BCA ASSESSMENT REPORT

**Lot 201, ESR Horsley Logistics Park
Horsley Park**

**Prepared For:
ESR Australia**

Date: 29 April 2021

1 Site Facilities Plan (Lot 201)
MS-A010 1:500 @B1

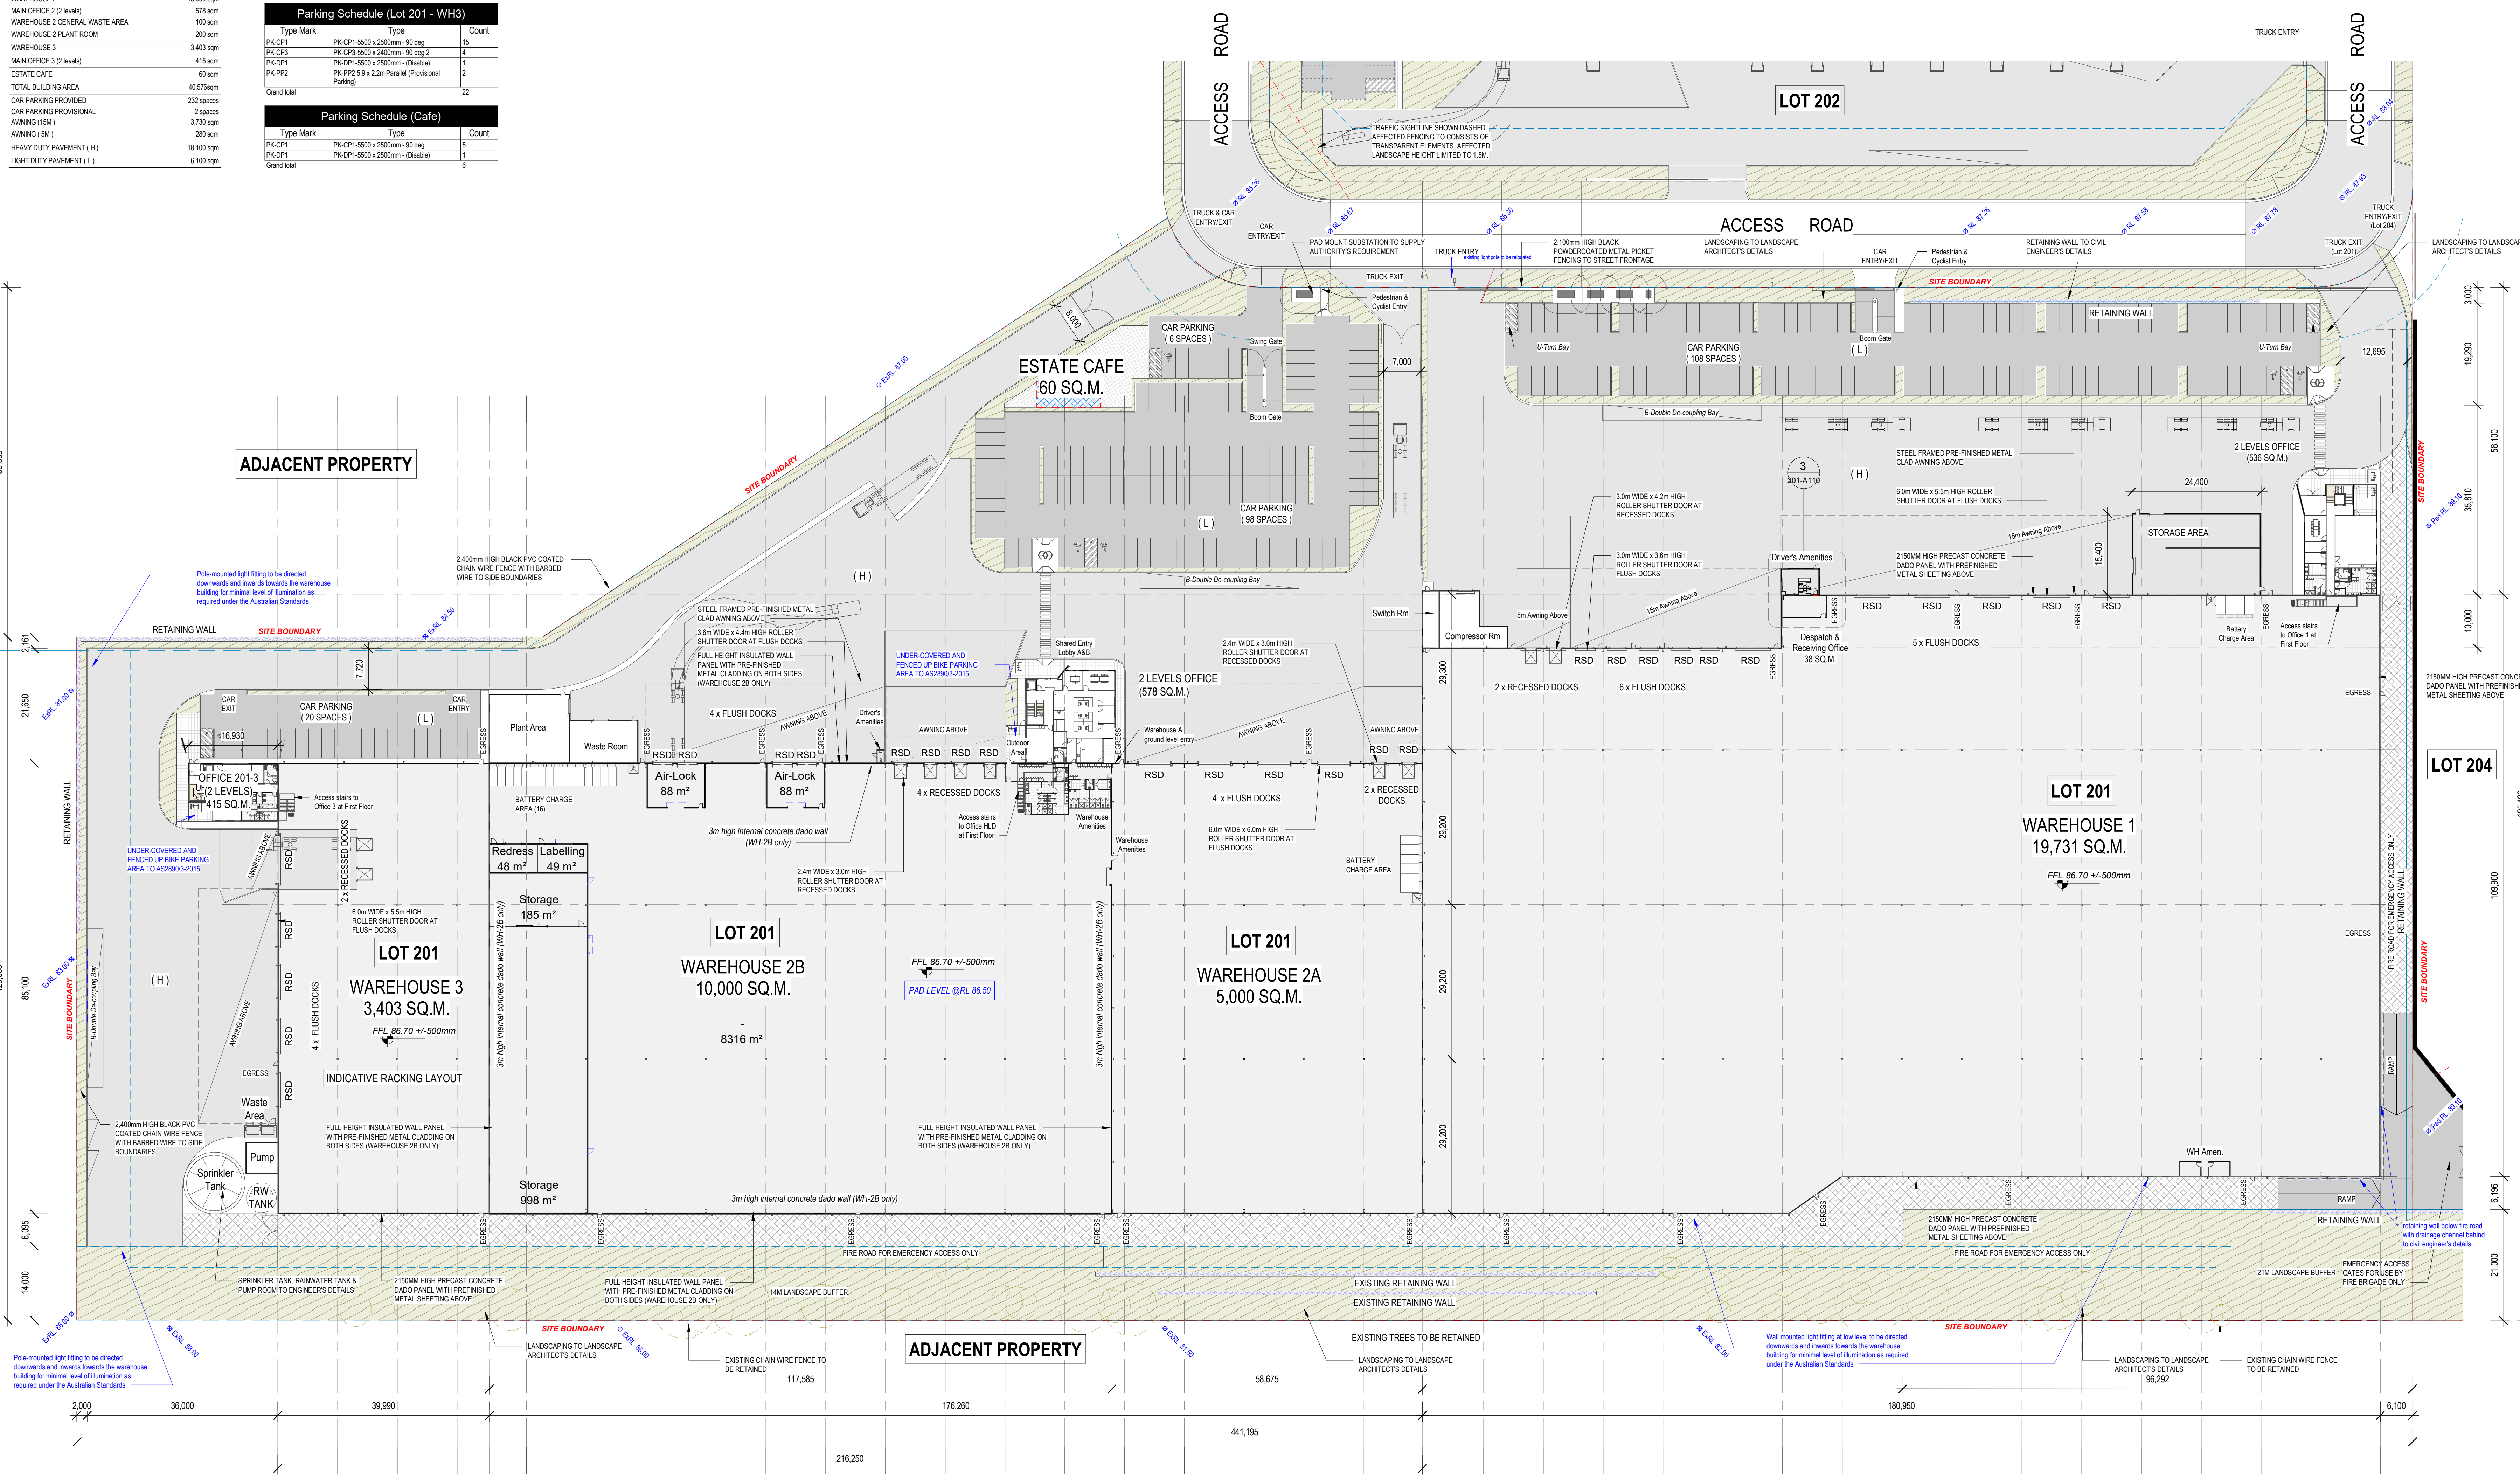
Comments: The proposed building does not comply with the provisions of C2.4 and thus the following non-compliance areas identified on the site plan are required to be addressed as a Performance Solution by the Fire Safety Engineer:

- The furthest part of the vehicular access path is greater than 18m from the external wall along in the locations shown in red below.
- The perimeter vehicular access on the southern side of the building is less than 6m wide.

Note 1: The driveways providing vehicular perimeter access must be designed with adequate loading capacities to withstand a fire truck and the gradients of the ramps should take into consideration to the FRNSW Policy 4 Vehicular Access Guideline.
